**CITY OF PORTLAND, MAINE
DEVELOPMENT REVIEW APPLICATION
PLANNING DEPARTMENT PROCESSING FORM**

Single Family S/F
Project Name/Description

Tucker Ave, Portland, Maine
Address of Proposed Site

From: Jay Reynolds
To: Doug Reynolds
Date: Wed, Nov 5, 2003 2:53 PM
Subject: Tucker Ave. review Comments

Drawing Name:	Layout and Utility Plan
Project:	TUCKER AVENUE, PORTLAND

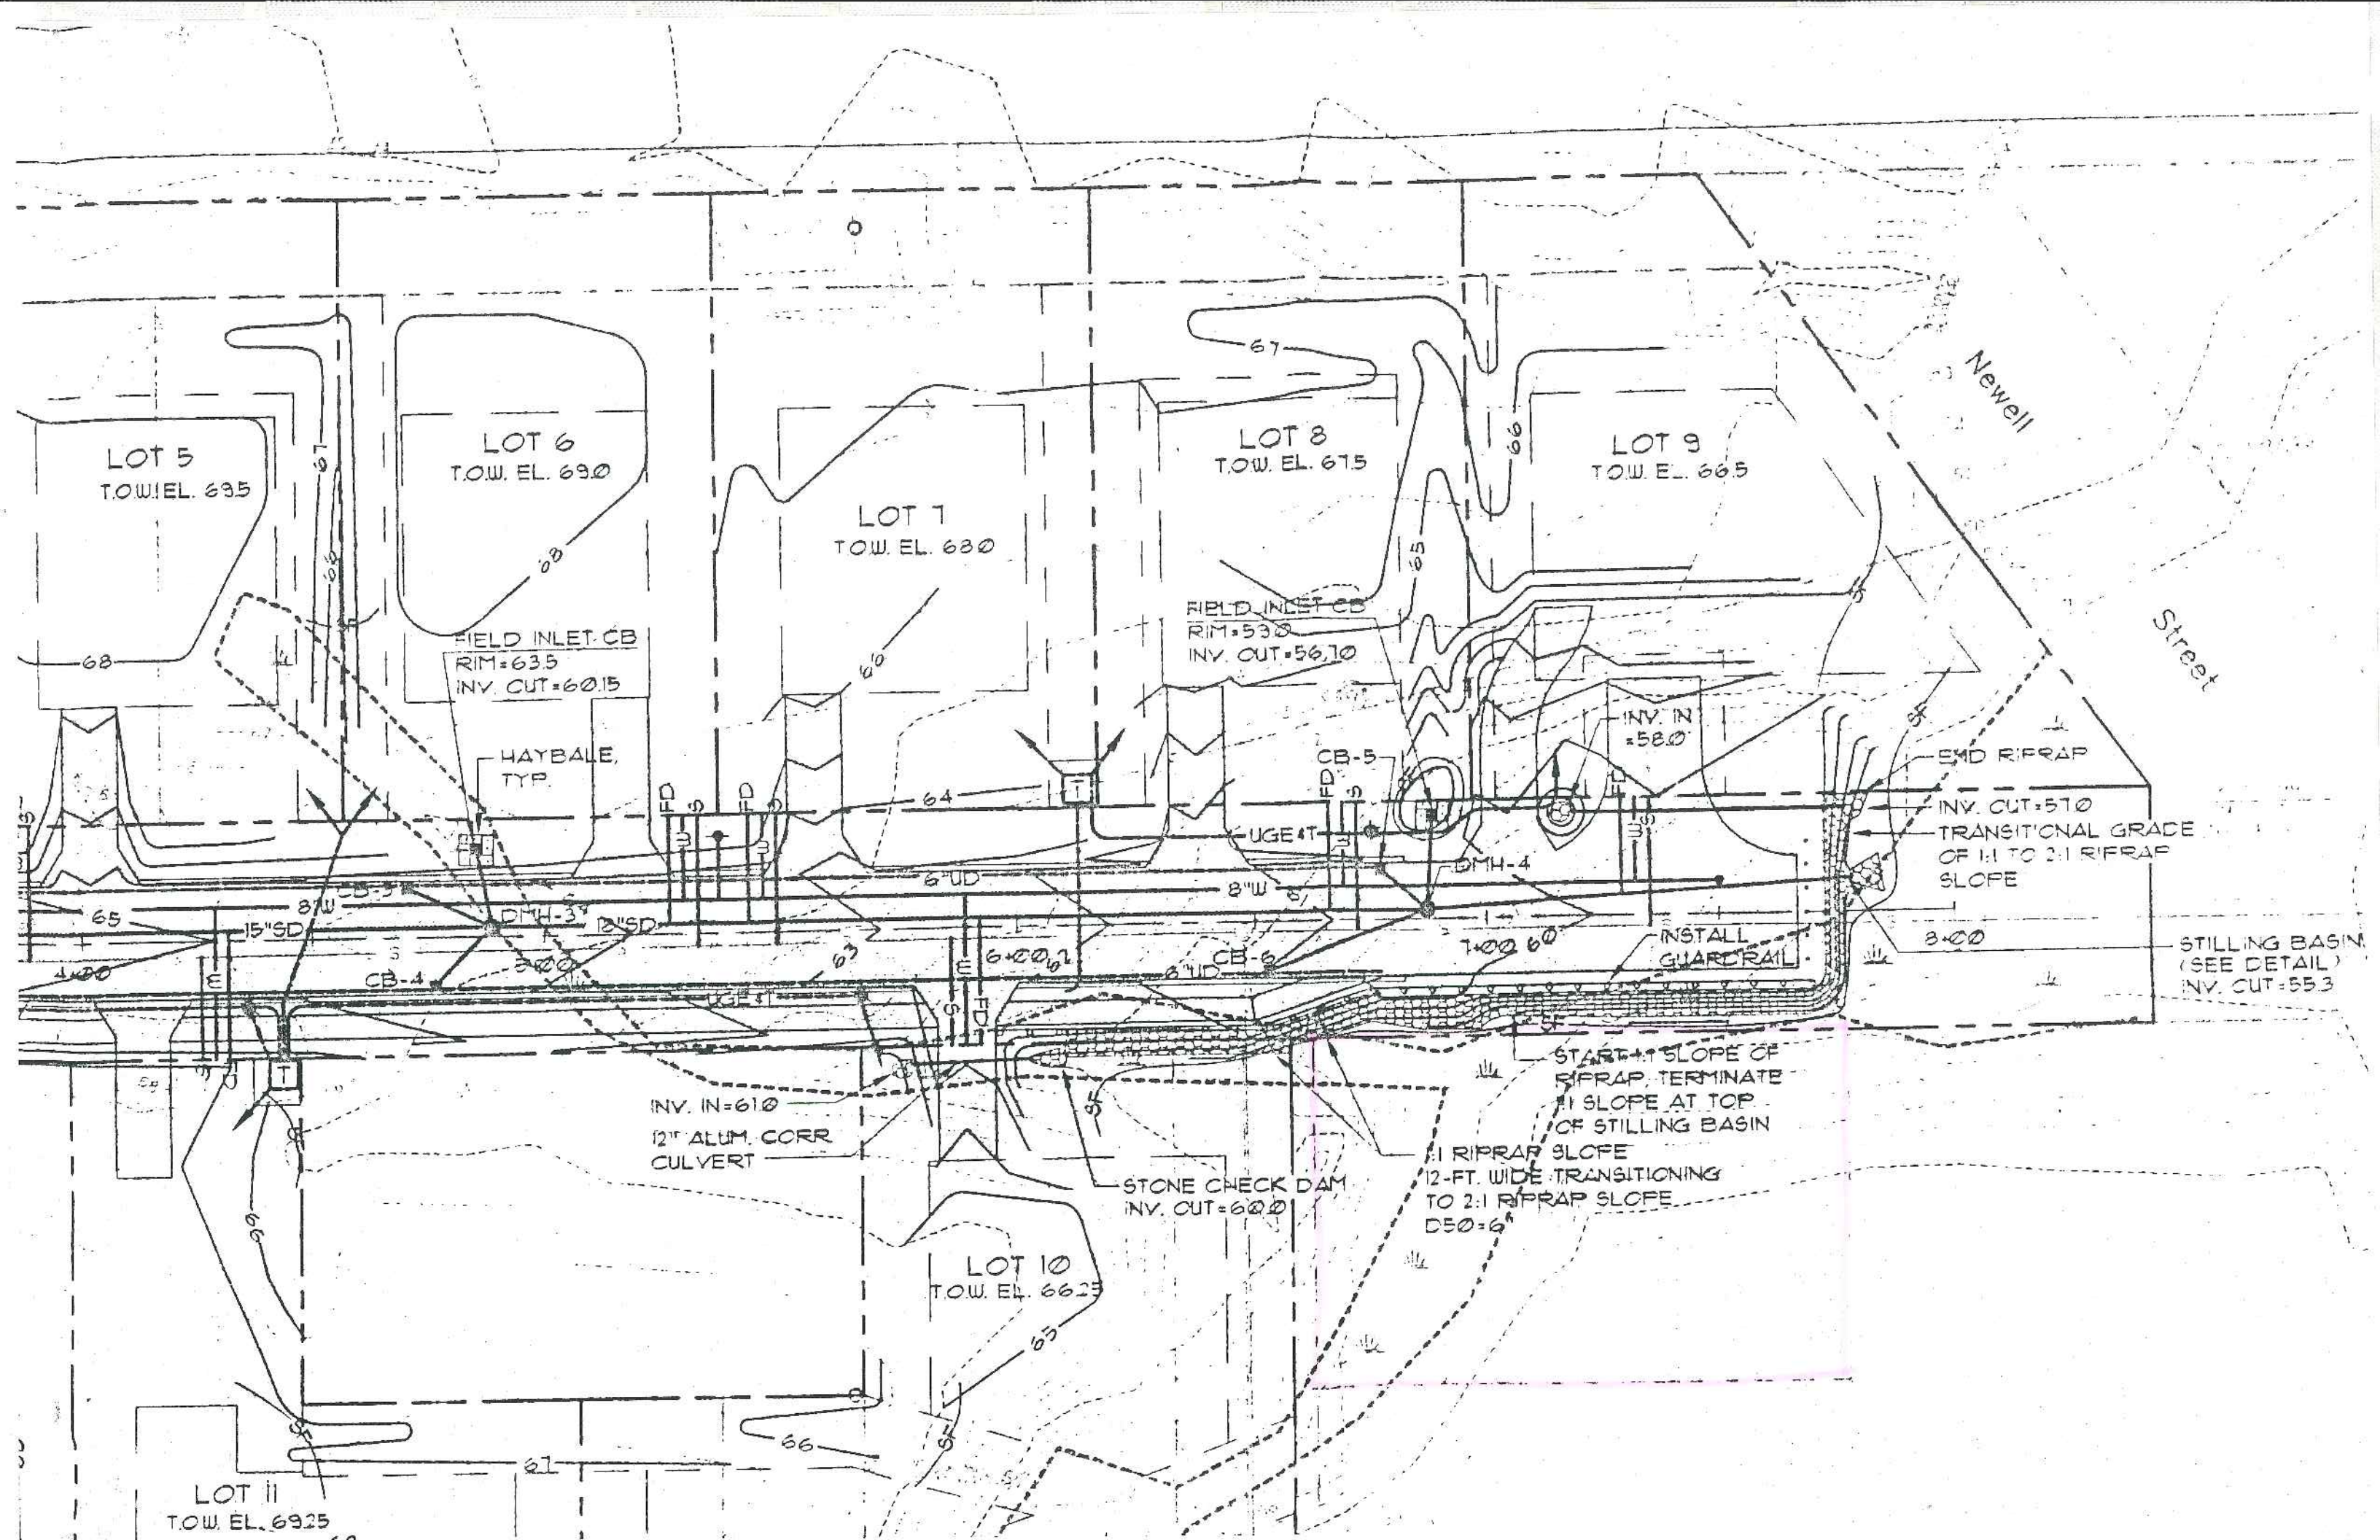
- 3. This proposal would involve the removal of some guard rail. What is the overall plan for this?
- 4. What is the design for Power/Cable/Telephone? (All utilities for the previous subdivision are in place, underground, for the use of the existing houses) *encasement of lines / review plans show connection*

- ✓ 5. A water main marker is located in the middle of the proposed driveway. Will this marker be relocated, *✓ OK* or the driveway moved?
- ✓ 6. FYI, this street may be a 5 year moratorium street, which may change the street opening permits/fees considerably.

- 7. The Tucker Ave. subdivision plans reference a 'stilling basin' as installed as part of the subdivision. This appears, but is not clear, to be in the vicinity of the proposed inlet/rip-rap apron. Please identify if this exists and locate it on the plan to ensure its' preservation. *Verify + show on site plan*

Drawing Name:	Site, Grading & Wetland Fill Plan
Project:	TUCKER AVENUE, PORTLAND

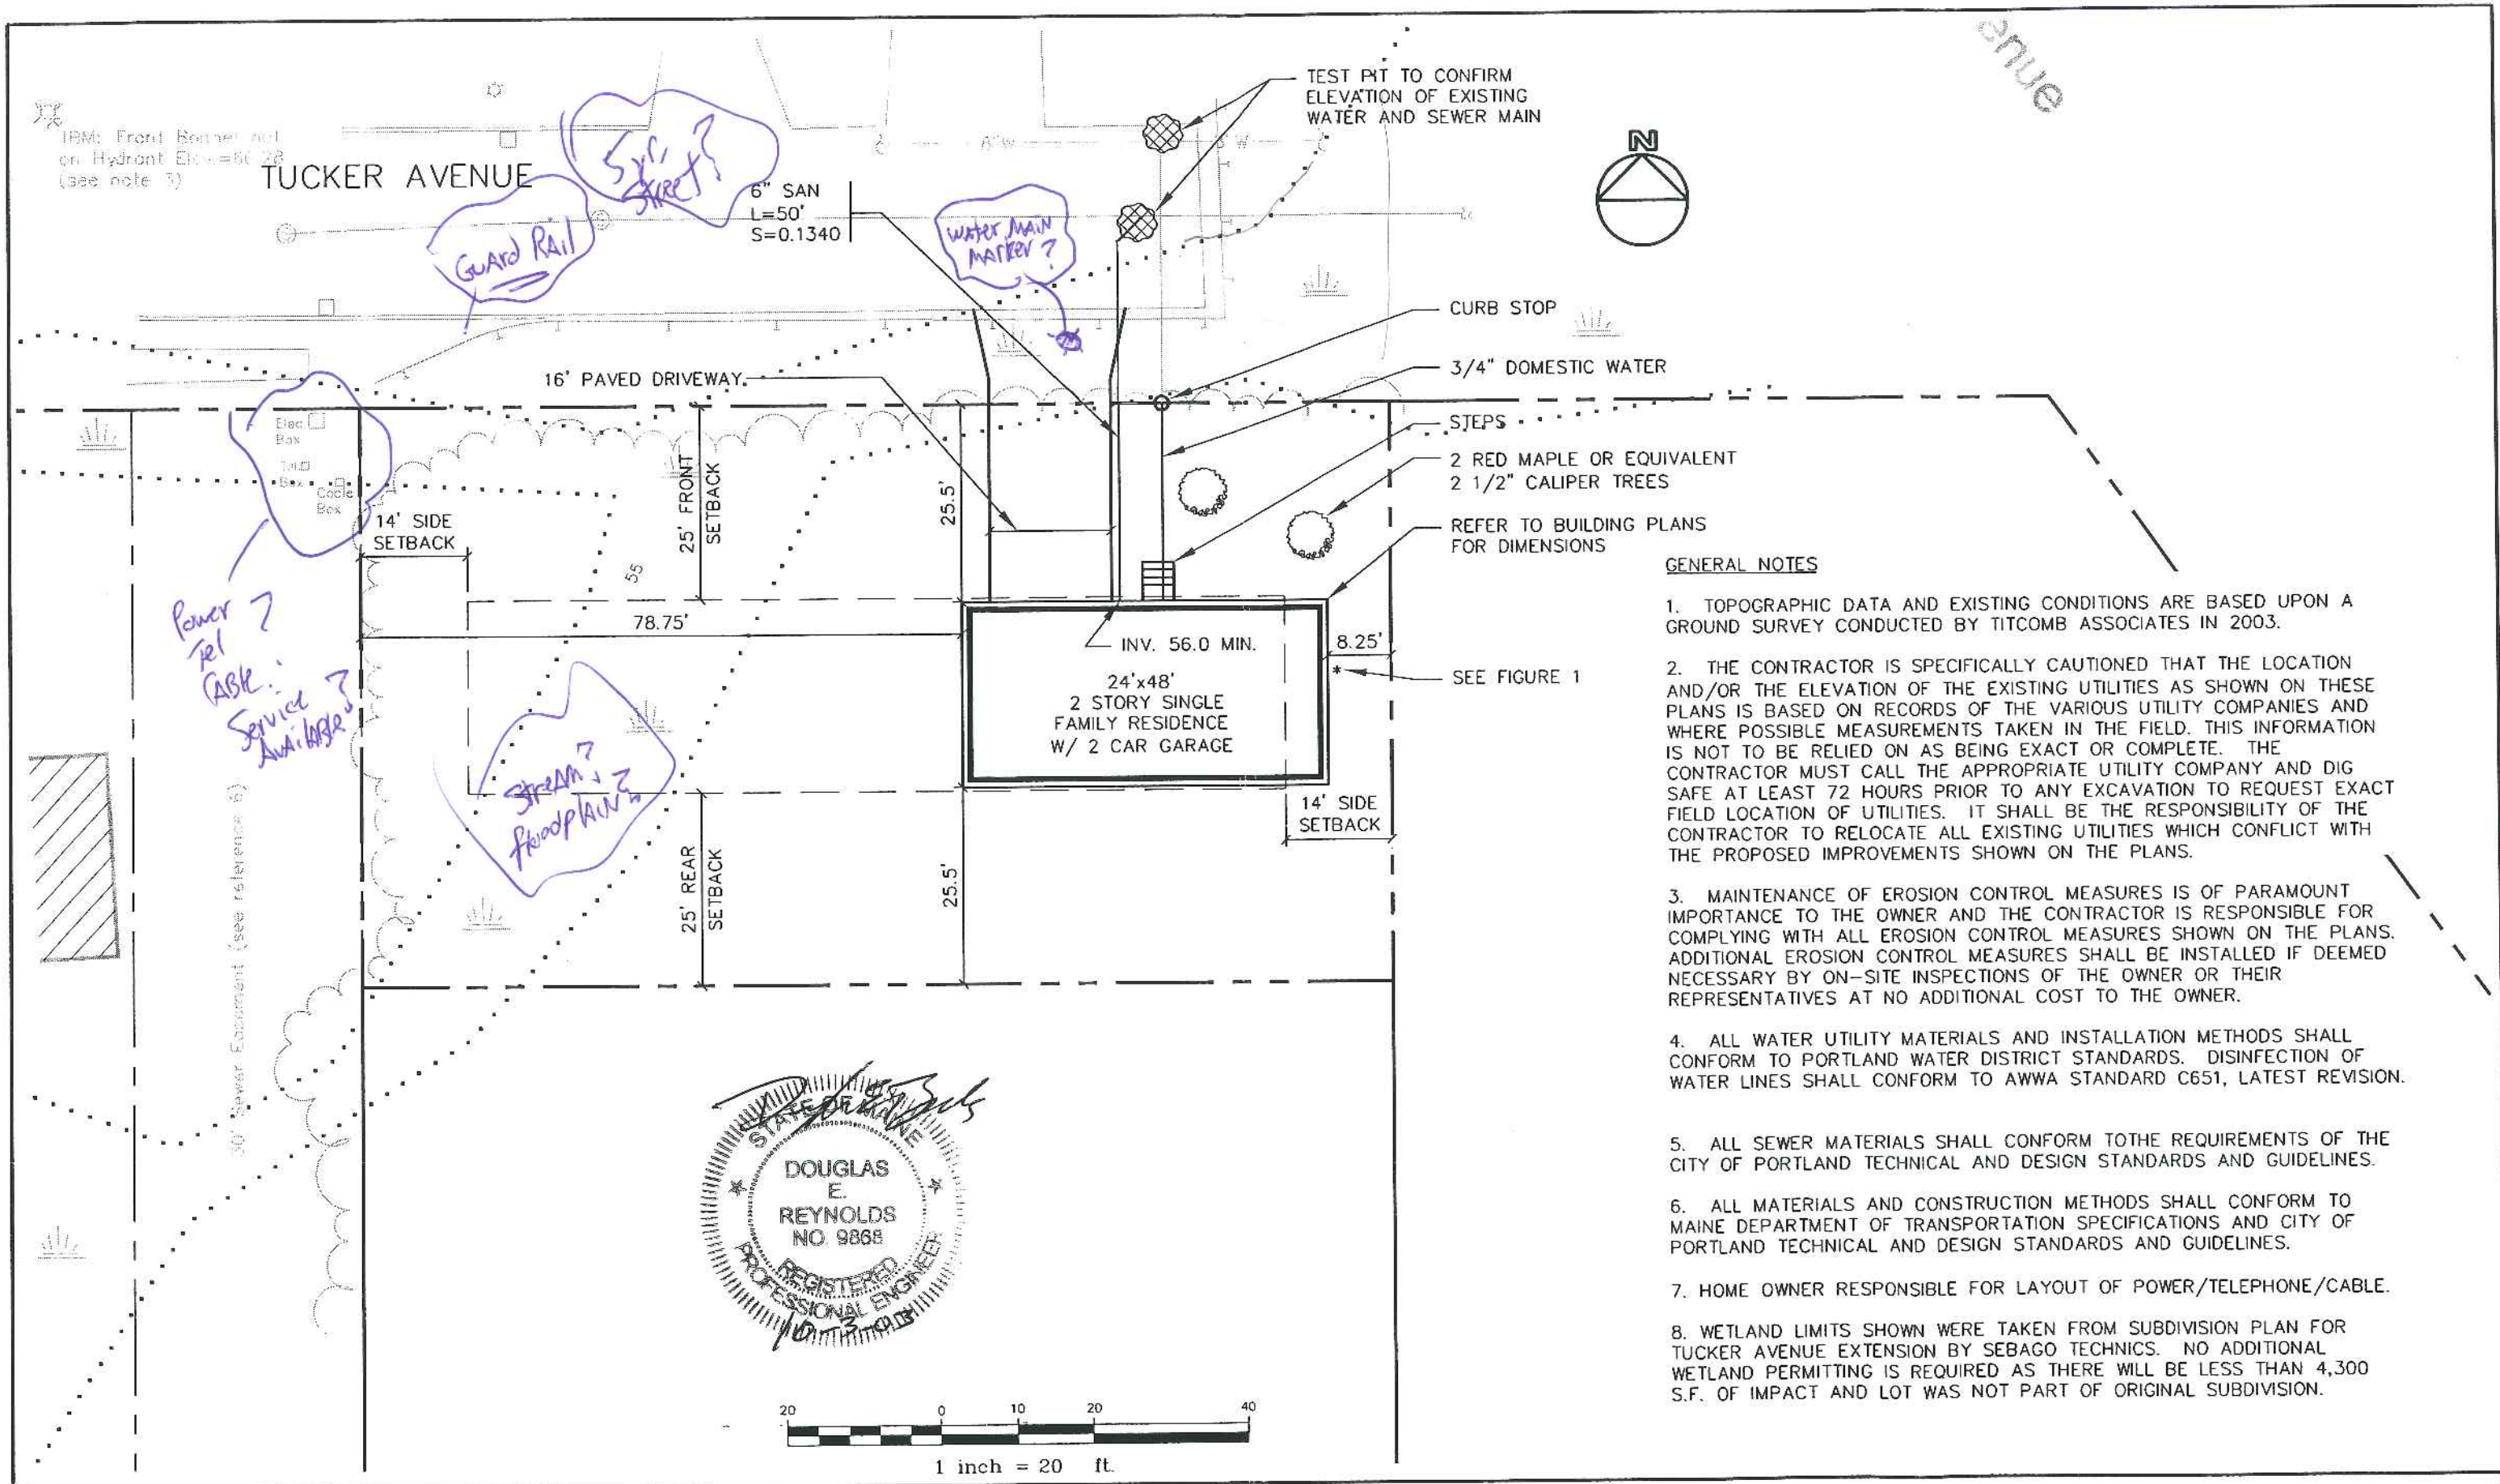
- 1. Zoning- this application would require extending the road per 14-403 requirements. *Respond in writing*
- ✓ 2. Is this an existing lot or are new lot lines being introduced? *Partial Permit / Public Works App.*

Tucker Ave: zoning is ok except for the 14-403 street - it looks like it needs to be extended to the end of the property (it is short of that now per the plans). Also, does public works want a turn around at the end?
